Cur Case Number: ABP-314942-22

Re: BusConnects Lucan to City Centre Core Bus Corridor Scheme
Lucan to Dublin City Centre

Ref: Bus Connects Dublin, Core Bus Corridors Infrastructure, Lucan to City Centre Scheme

| Drawing File Name BCIDA-ACM-GEO_GA-0006_XX_00-DR-CR-0015 | Sheet Number 15 of 31 | Status A | Rev M01 |

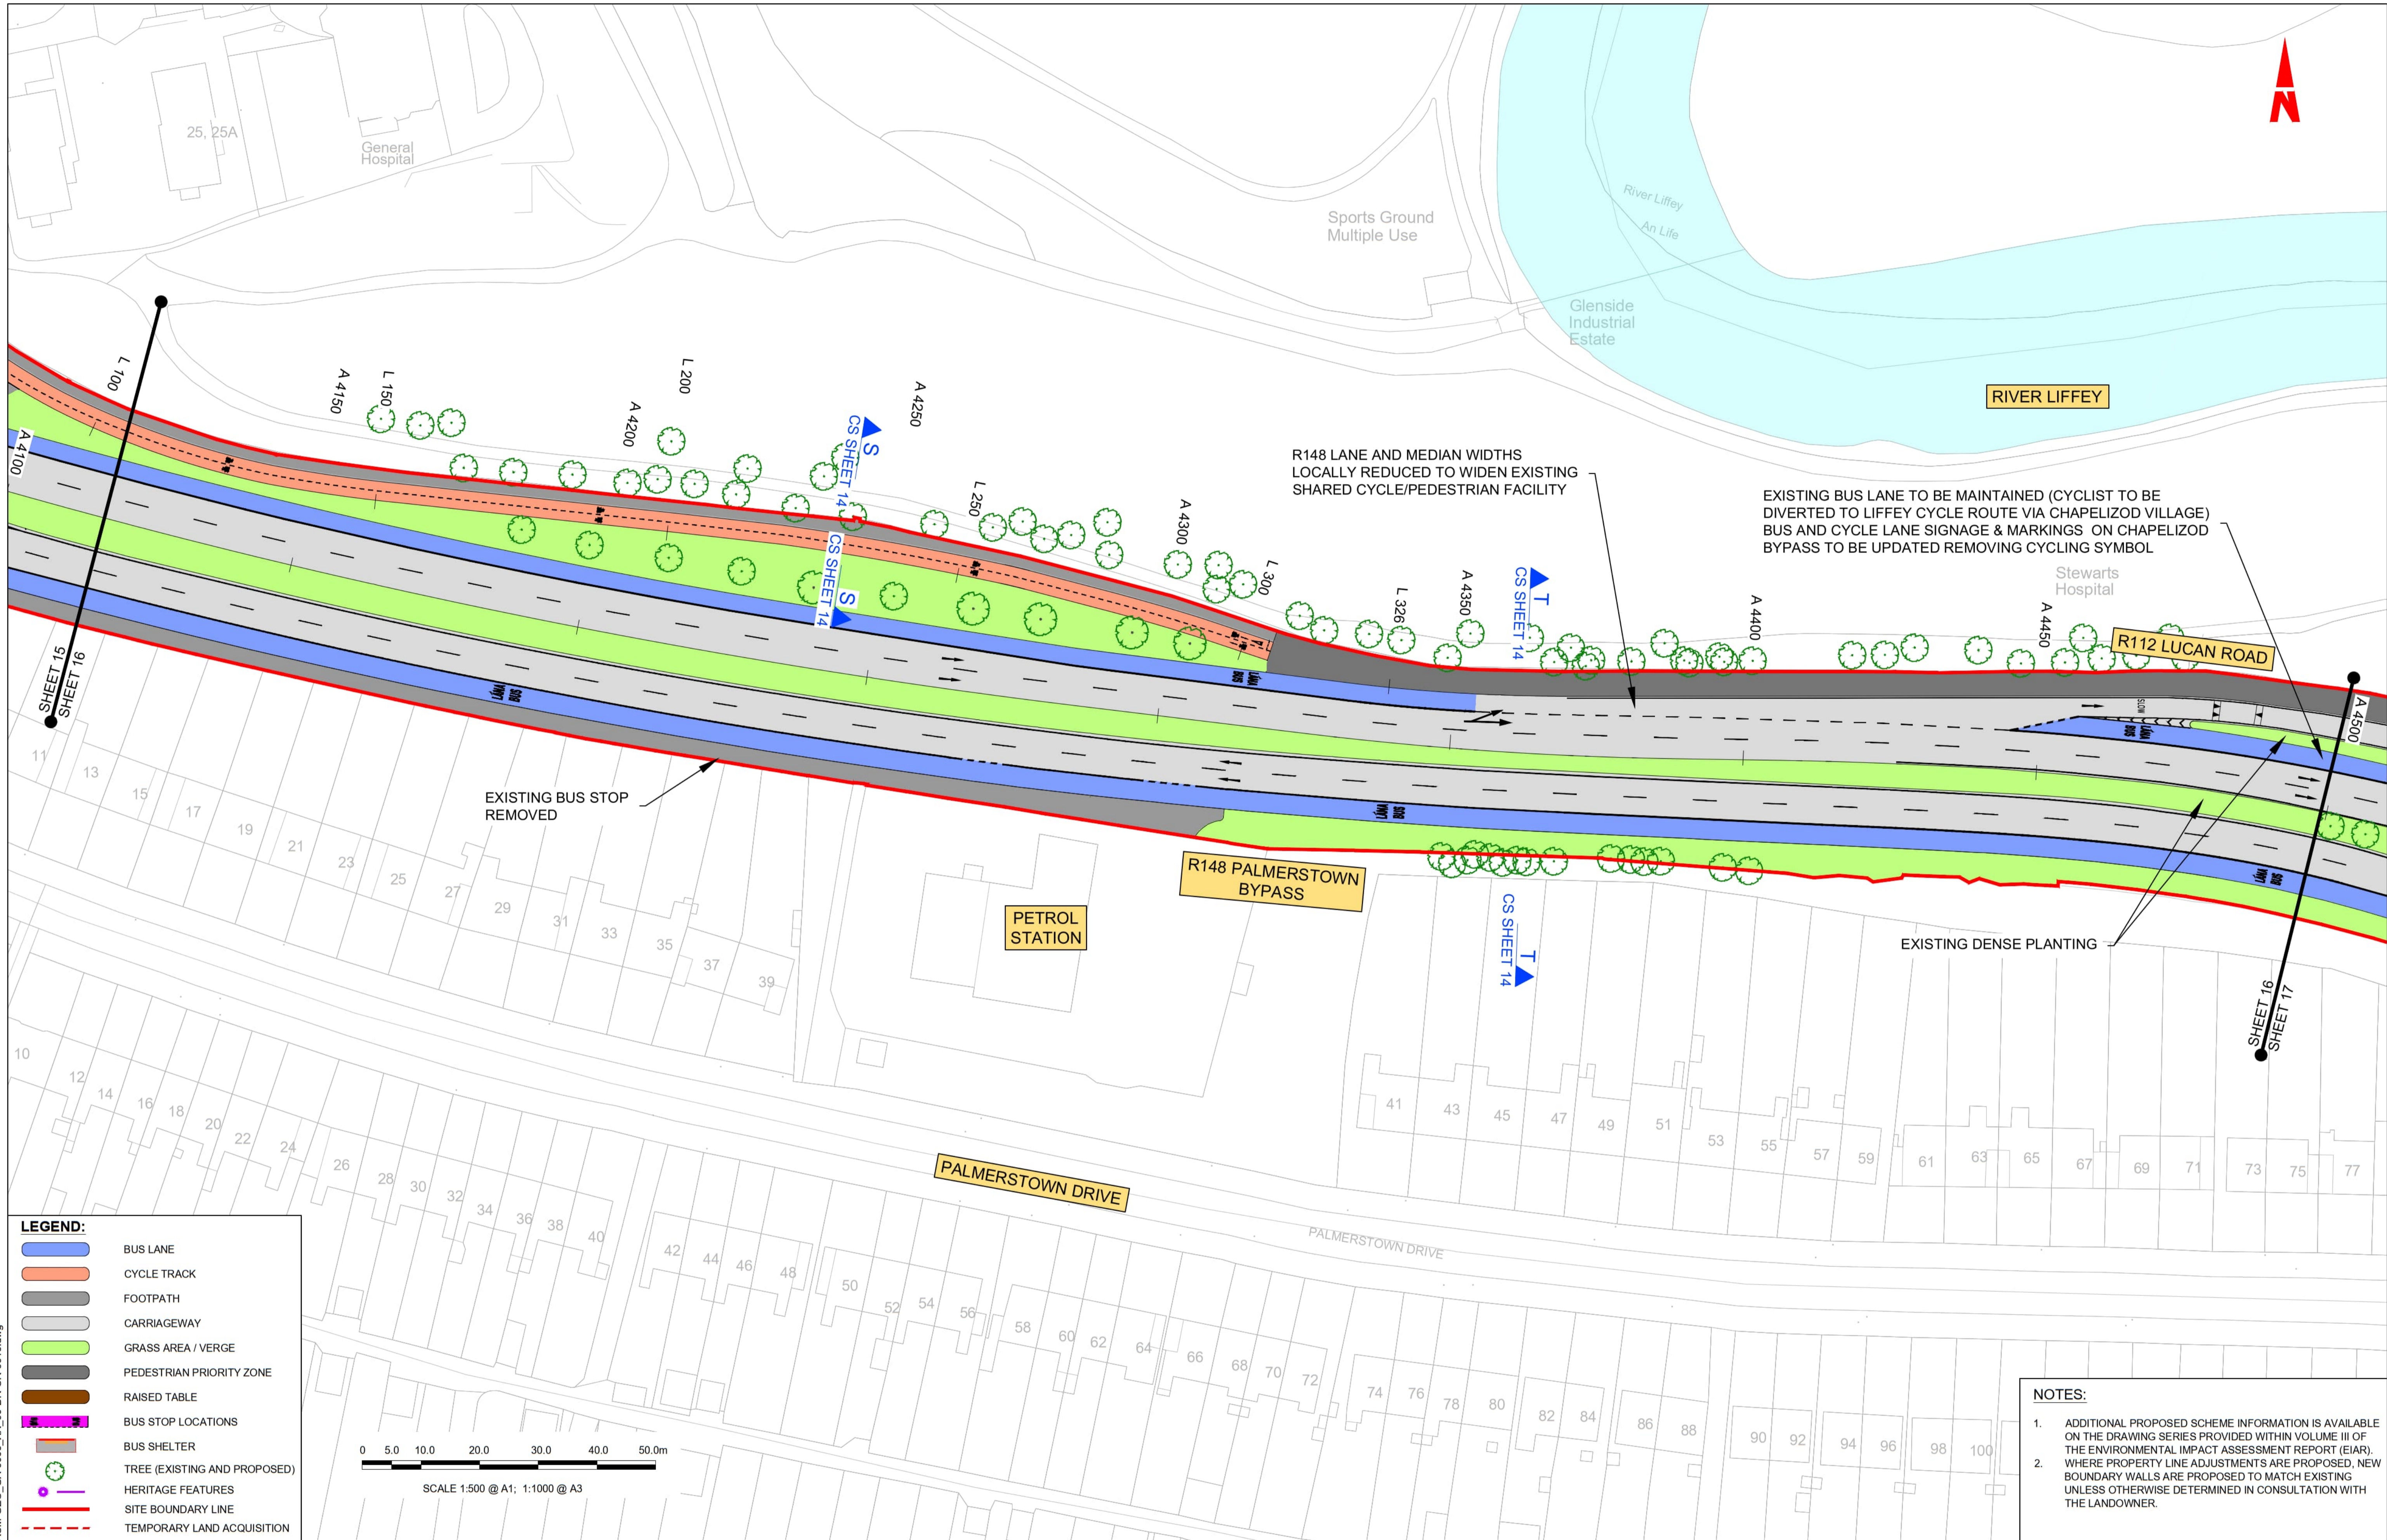
I am writing to you to make observations on the above application scheme particularly as it relates to the Palmerstown Village portion of the project. Referenced mainly by drawings DR-CR-0014, DR-CR-0015, DR-LL-0014, DR-LL-0015, DR-ES-0014, DR-ES-0015 and related documents.

We would request a Further Information on the exact materials to be used to make all of the changes proposed, cycle lane surfacing, raised tables, and all street furniture etc. The historic importance of old Palmerstown must be protected. In recent years it has been eroded more and more and its specific historic character is being lost. We particularly would be against excessive bollarding of cycle lanes which is a blight on the whole city at present, turning many areas of our city into a visual mess subtracting from areas of architectural importance.

The potential siting of a bus stop in front of RedCow cottages will detract from this architectural vista, this location should be revised. The overall choice of materials needs careful consideration and no such specification is currently in the documentation.
